Subject: Revised EES comments on Response to Submissions and further amended Concept Plan for Harbourside Shopping Centre – SSD-7874 – Darling Harbour

Subject: EES comments on Response to Submissions and further amended Concept Plan for Harbourside Shopping Centre – SSD-7874 – Darling Harbour

The Environment, Energy and Science Group (EES) has reviewed the following reports for this SSD:

- Response to Submissions and Further amended Concept Plan (RtS) – 12 October 2020
- Appendix H – Landscape Design Report (LDR) – October 2020

1 DEMOLITION PLAN
3000-00 1:500

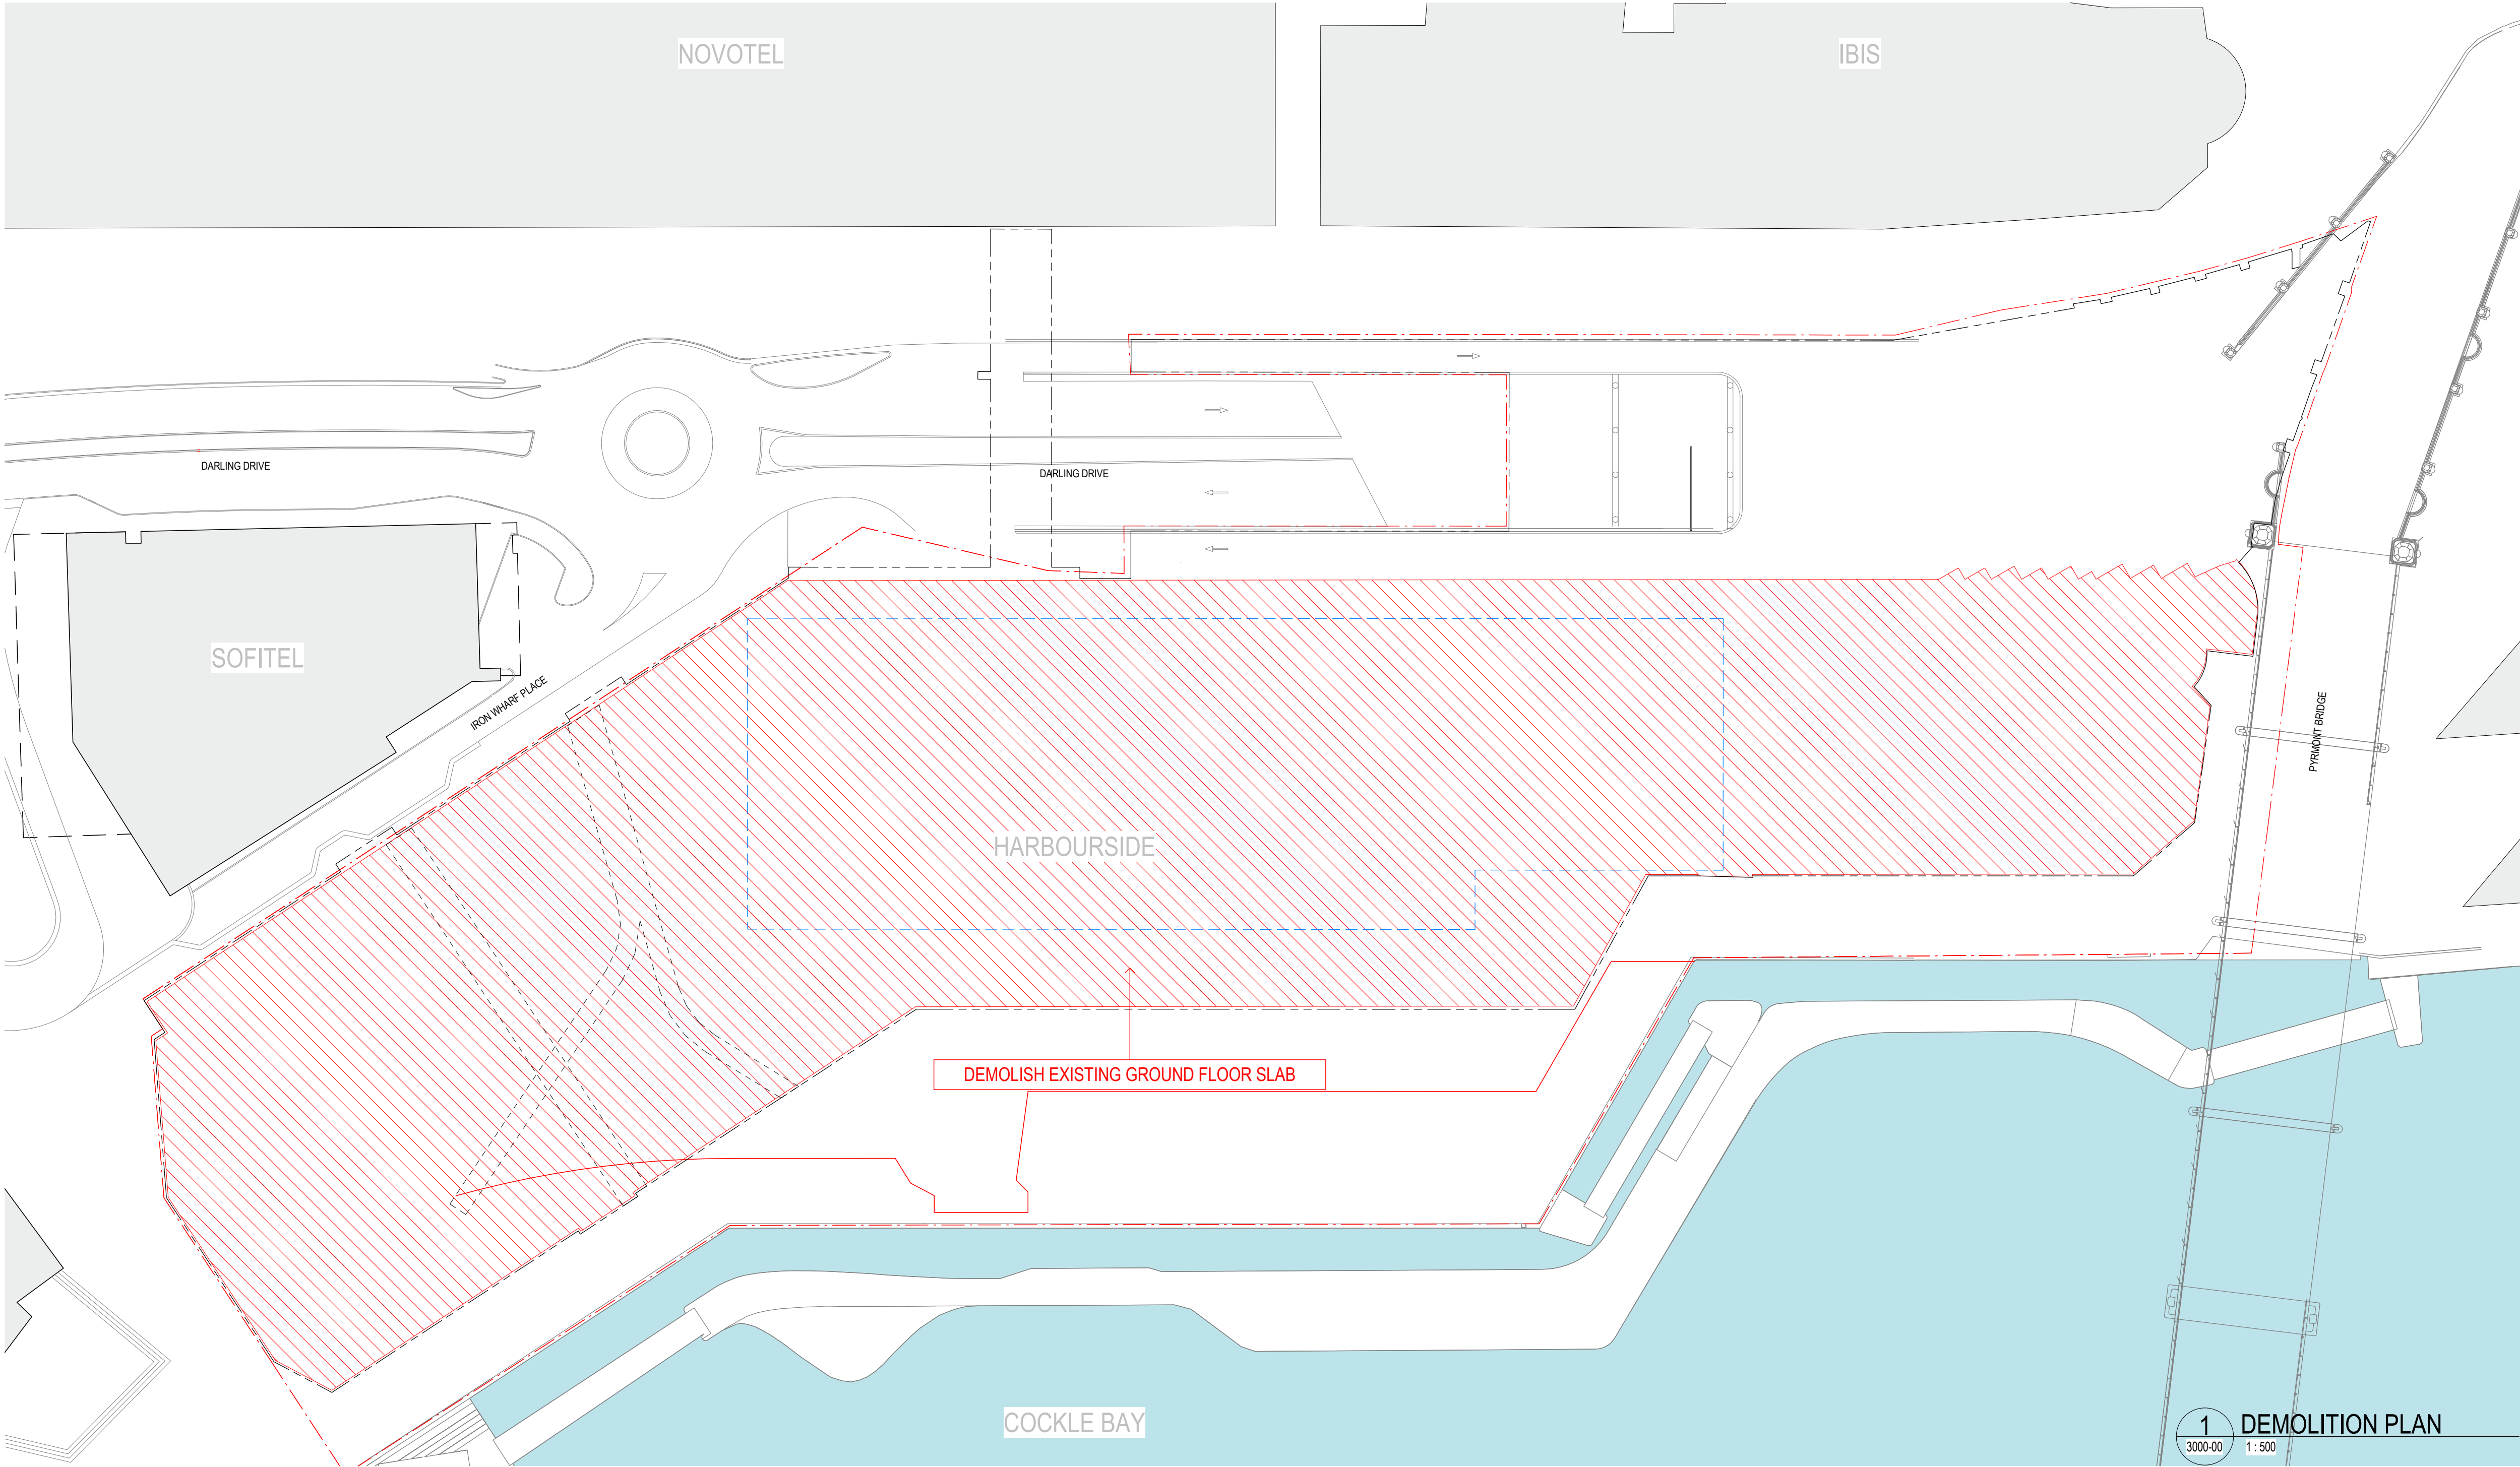
EES notes previously, no physical works were proposed as part of the concept DA and demolition was to be subject to a future Demolition DA following the approval of the concept application. However, approval is now sought for Stage 1 demolition works (physical works) involving the demolition of existing site improvements, inclusive of the Harbourside Shopping Centre, existing Monorail station, and existing pedestrian bridge over Darling Drive and associated tree removal down to ground slab level (no ground disturbance) as part of the concept DA approval process (sections 3.5.8 and 4.2 of 61 of RtS).

The amended Concept Plan has not considered the presence and possible value of habitats afforded by the existing artificial/built structures, for example the existing building and pedestrian bridge. Several microchiropteran bat species, some threatened, are capable of roosting in a variety of natural and constructed sites, so it is possible that they might utilise the existing built features on this site.

Information is required to confirm the absence of roosting habitat for threatened microbats within the existing buildings. A search for evidence of microbat roosts should be undertaken using appropriate methods, such as those described on page 9 of the '*Species credit' threatened bats and their habitats NSW survey guide for the Biodiversity Assessment Method* (OEH 2018).

Pre-clearing surveys should apply to any buildings or structures with potential roosting habitat that are to be demolished and such surveys should be carried out by a suitably qualified and experienced microbat specialist and if microbats are present, then works should not be carried out when they are likely to be in torpor.
